2 February 2021

Application by Highways England for an Order Granting Development Consent for the A47 Blofield to North Burlingham project (TR010040)

Procedural Decision following issue of Acceptance decision

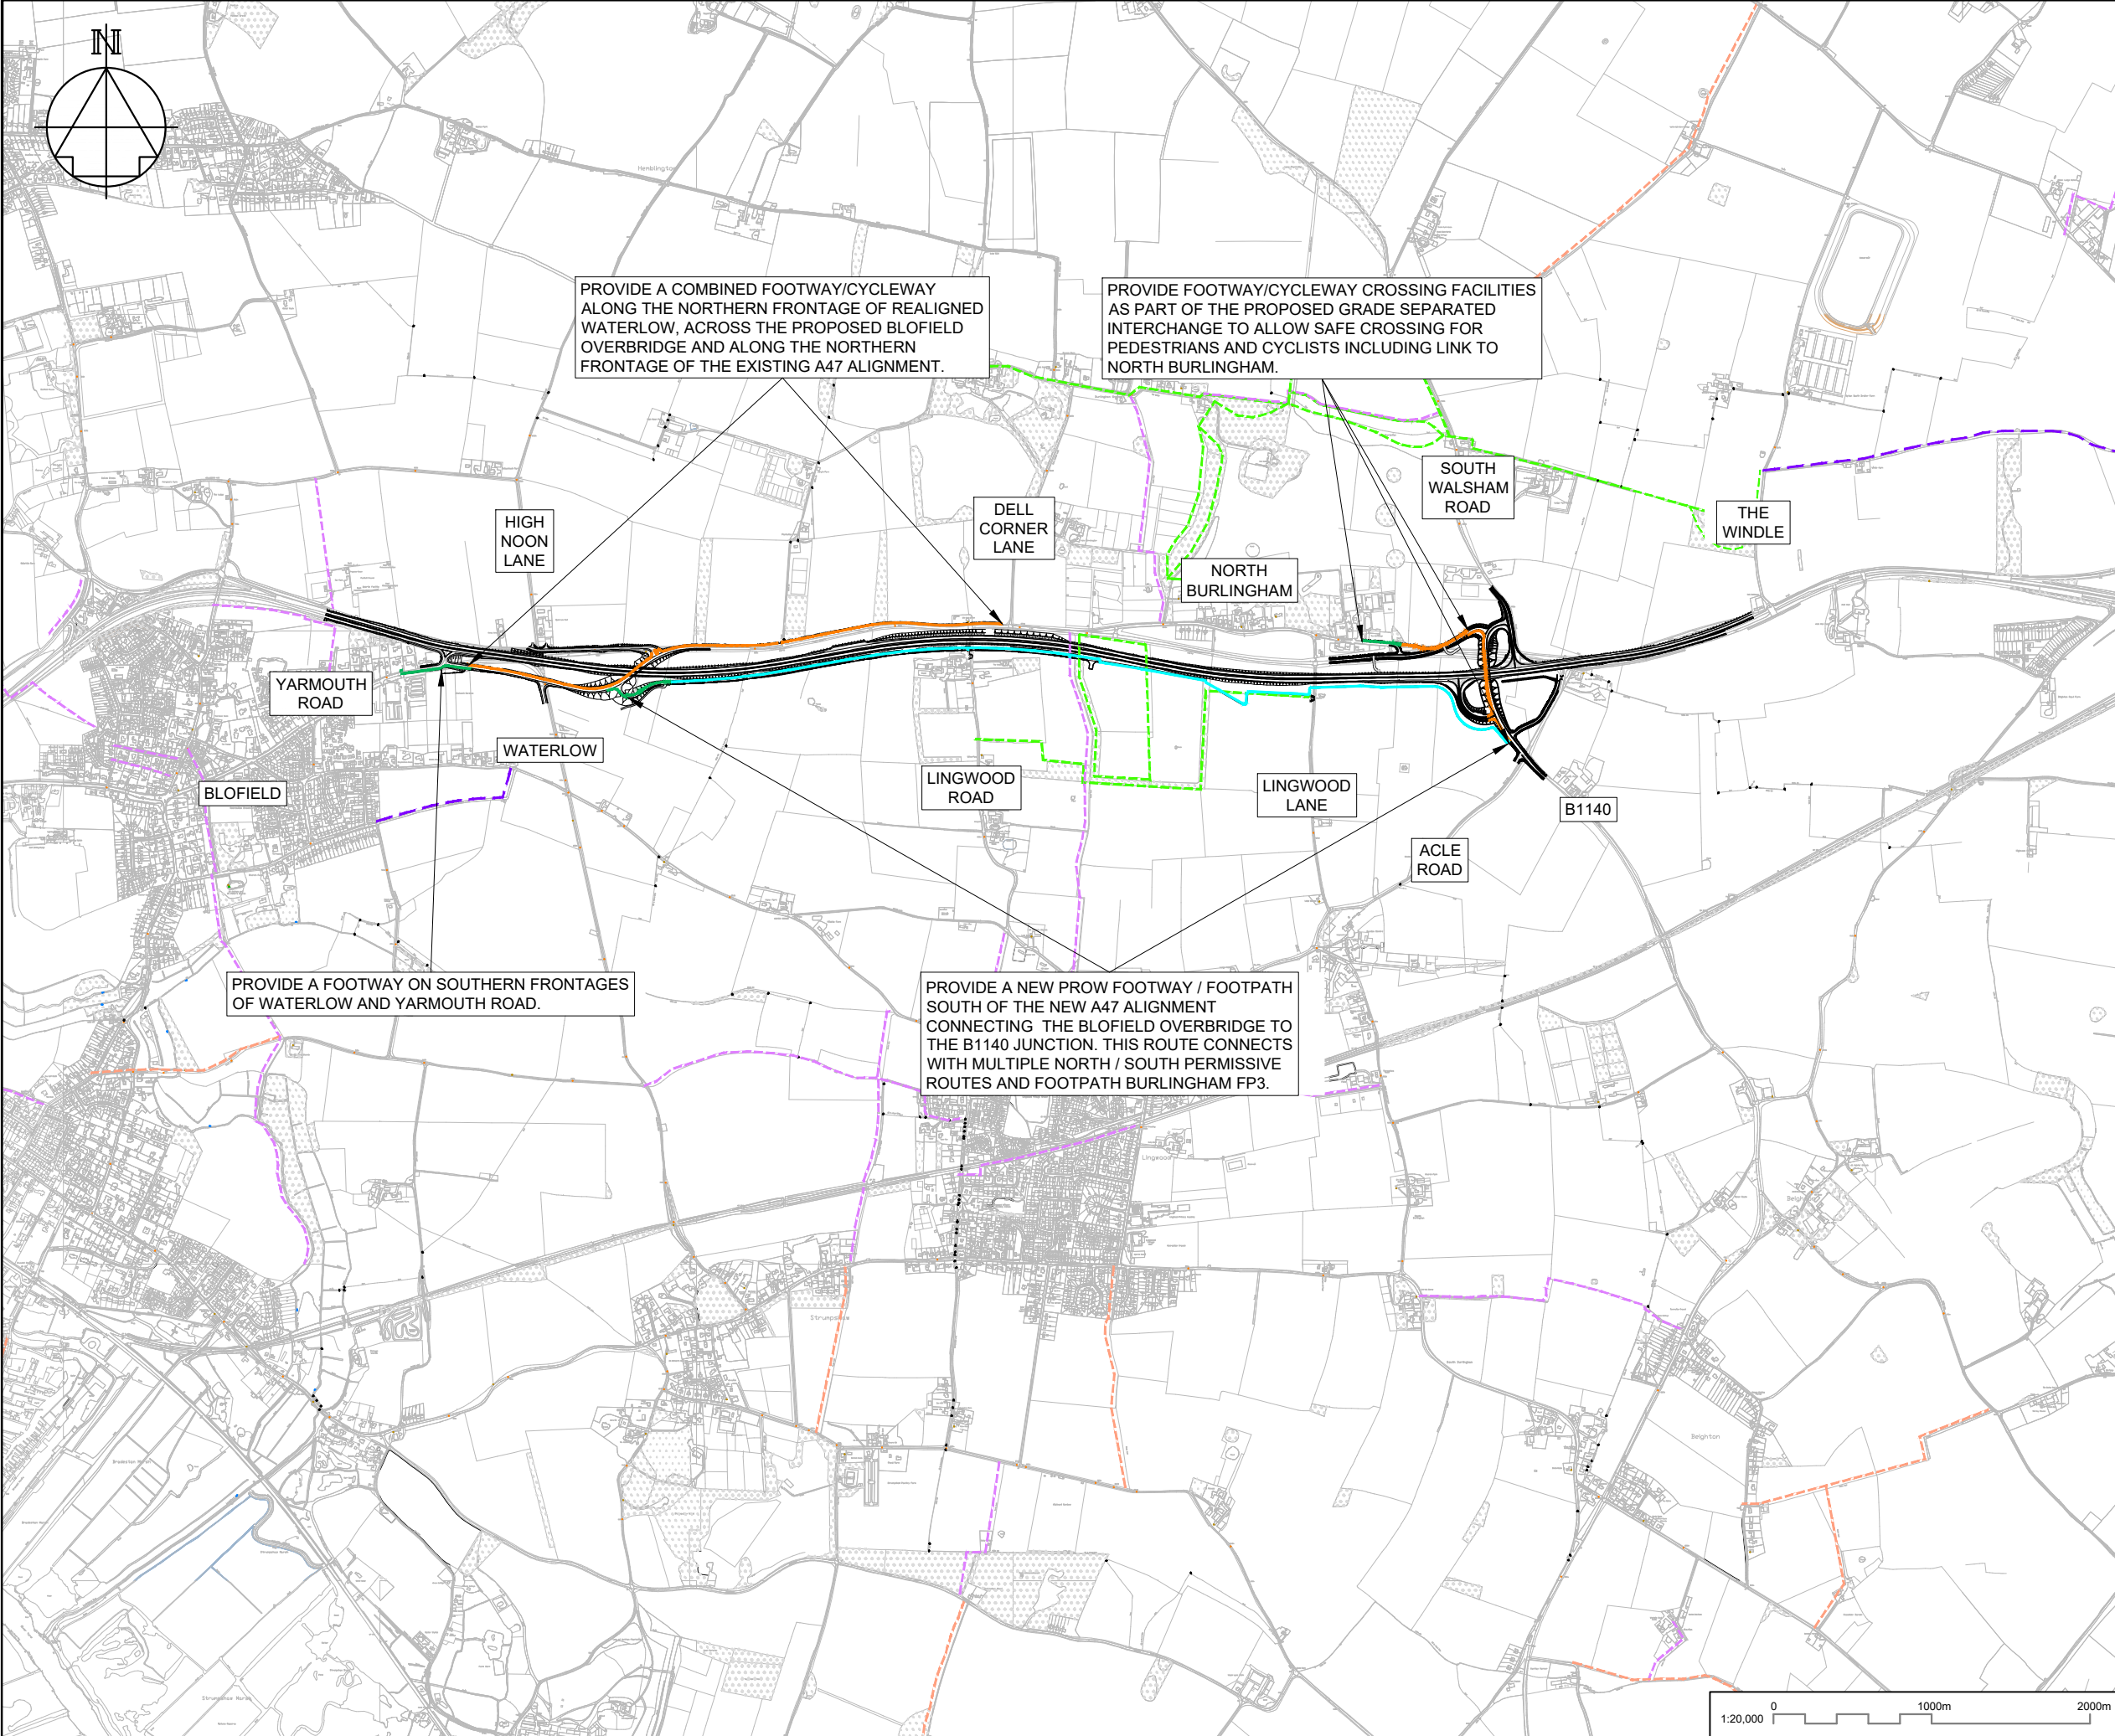
There appear to be some discrepancies between information shown on the Rights of Way and Access Plans and the General Arrangement Plans and information shown on ES Figure 12.2: Population and Human Health Design, Mitigation and Enhancement Measures (Doc 6.3). For example, the plans appear to show a cycle track over the proposed bridges and beyond, whereas ES Figure 12.2 suggests there would be a shared cycle track and footway. The Applicant is requested to ensure that there is consistency between all plans and figures and what is described in the associated documents.

**DRAWING TITLE**  
 FIGURE 12.3 - AGRICULTURAL LAND HOLDINGS  
 KEY PLAN  
 TR010040/APP/6.3

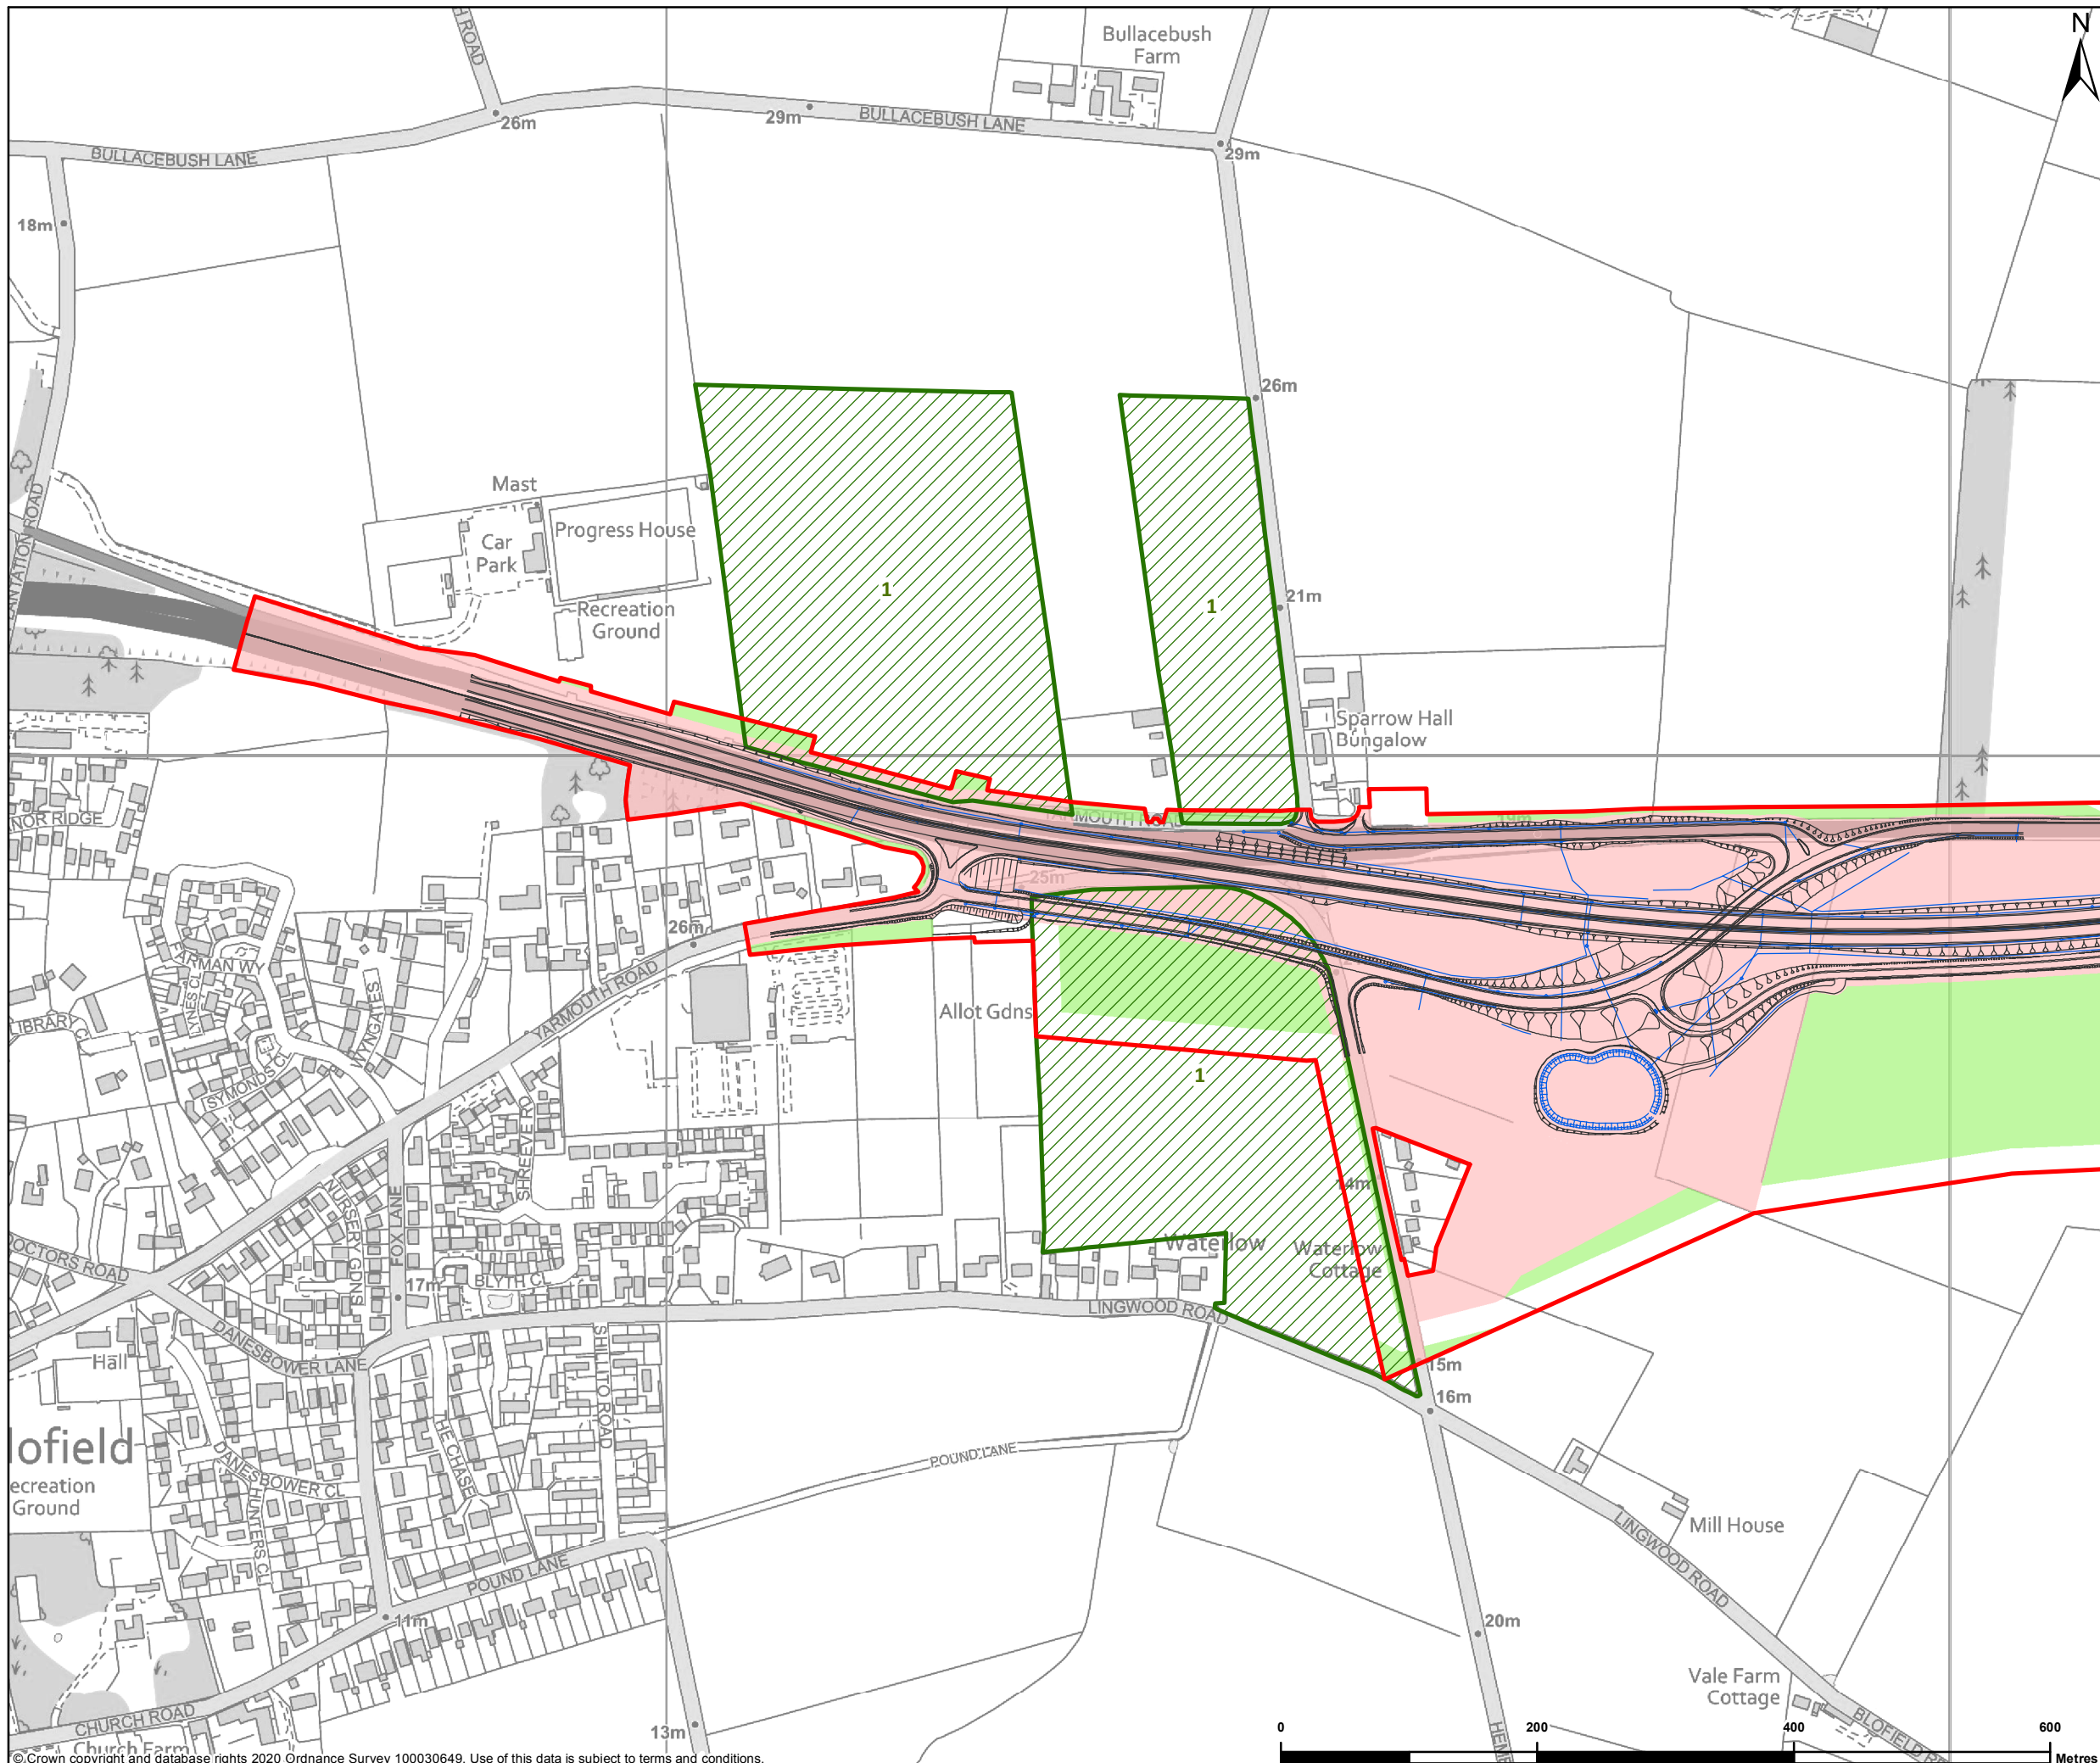
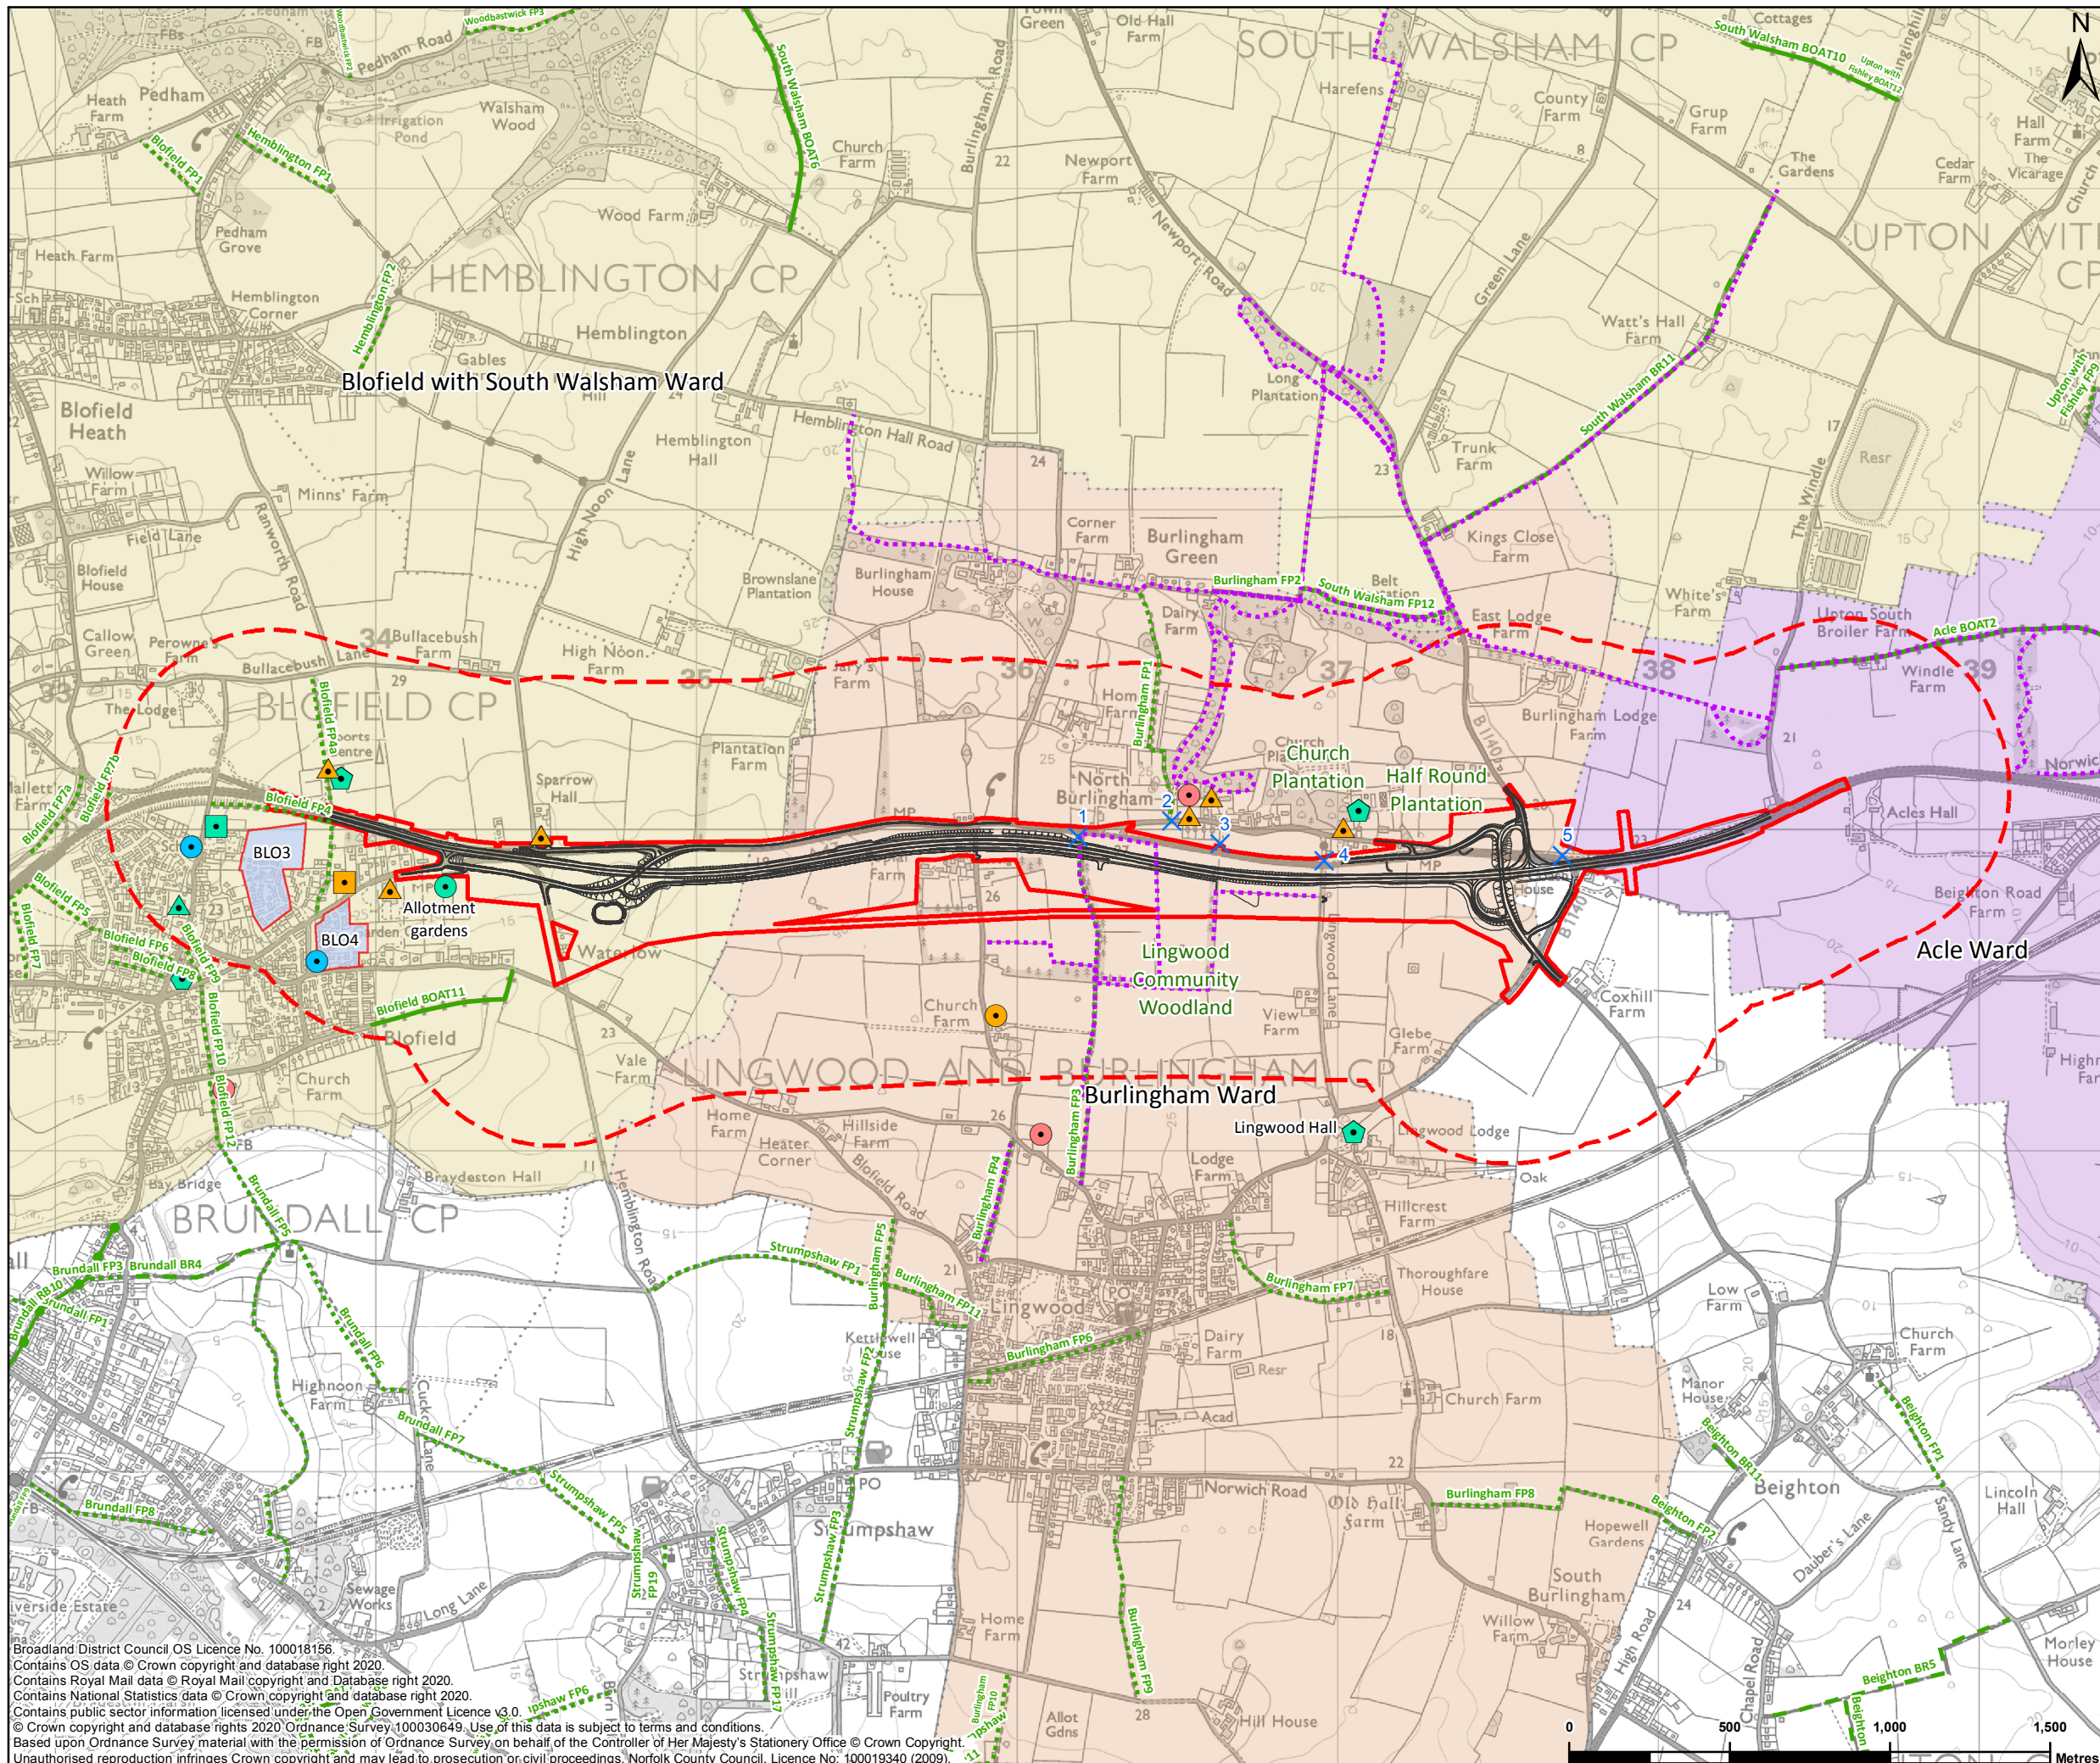
ES Figure 12.3 identifies areas of permanent (pink) and temporary (green) land take in respect of agricultural land holdings. However, whilst these areas are also identified on the Land Plans (Doc 2.2), the Land Plans additionally identify a further category in blue; land to be used temporarily and rights to be acquired permanently. The Applicant should consider whether this category should also be identified on ES Figure 12.3, and if so, amend it accordingly.
